Outline application for erection of detached 2 storey dwelling of sustainable carbon efficient design together with car parking space and bin storage area - Resubmission of EP/123/10

Crinnis Seafield Road East Preston

Re: OBJECTION AGAINST CRINNIS PROJECT - EP/136/11 ☐

EAST [sea road frontage] 1/100

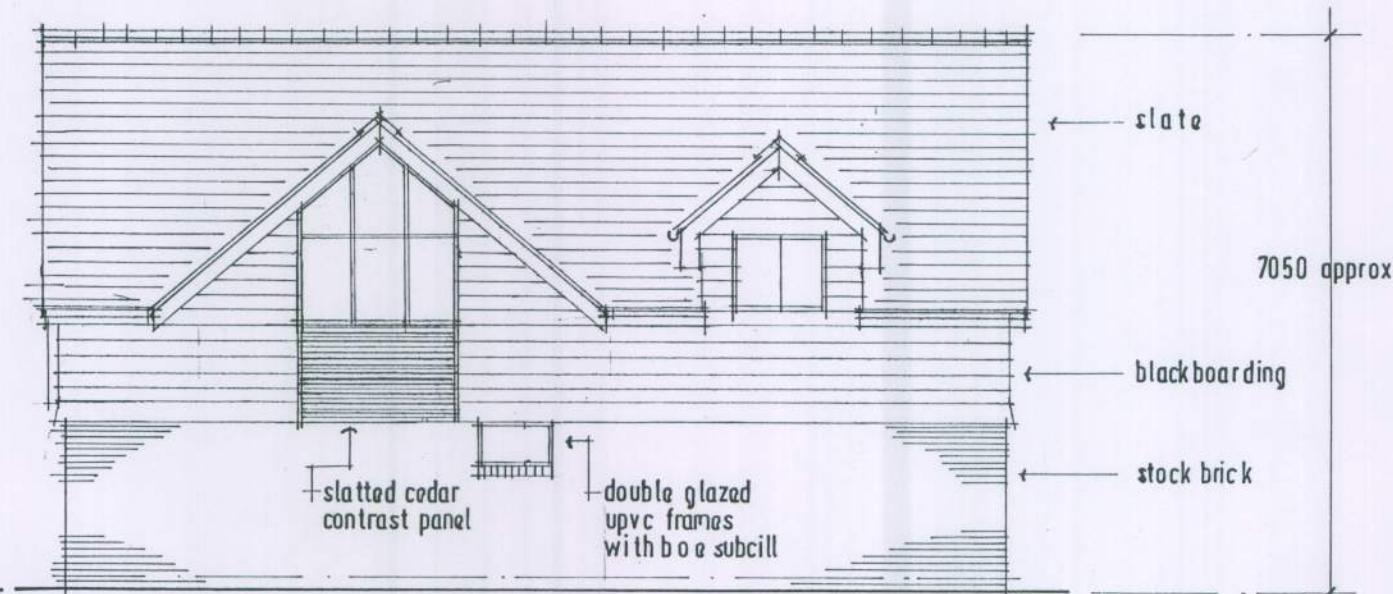
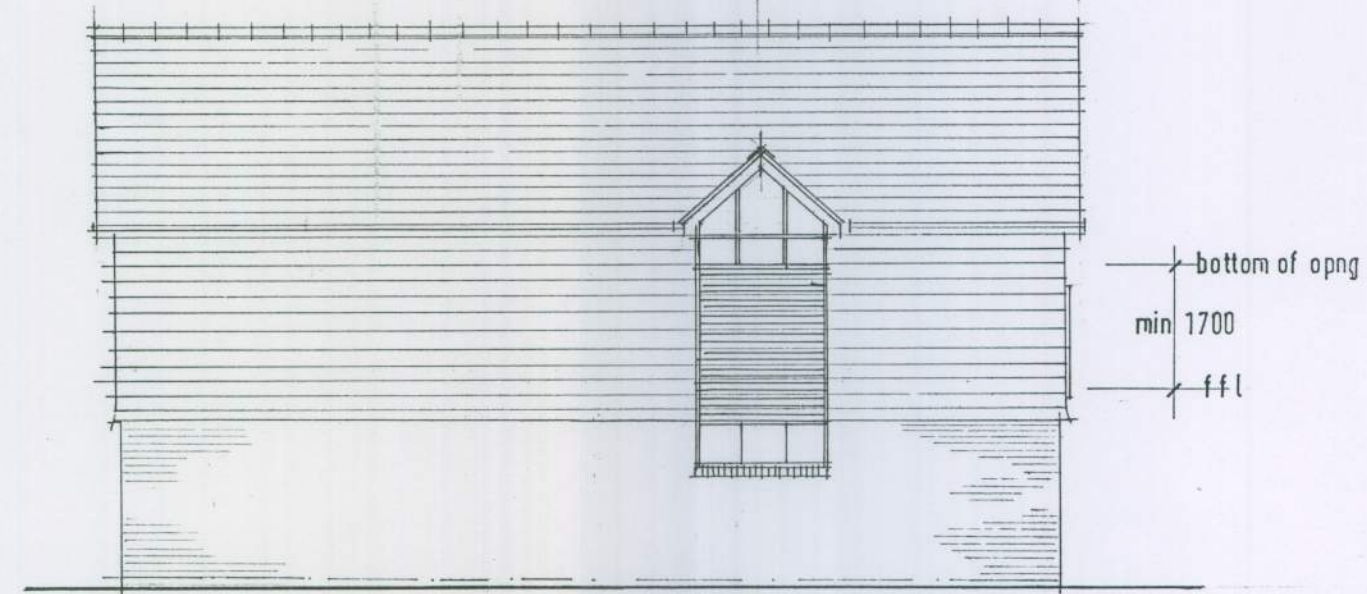
The reasons for rejection are equally valid for the current application. The east wall of the house has been moved less than 1 metre back from Sea Road, which would make no difference to the impact that a wall 7 metres high would have on the street scene. It would most certainly destroy the informal character of Sea Road at this point, which is a feature that the Area of Special Character was created to preserve. The plot size and garden size remain as before and so incompatible with the Area's low density.□

In my opinion this development should not be permitted, it will be detrimental to the area with a house right on the road and virtually no garden of its own.
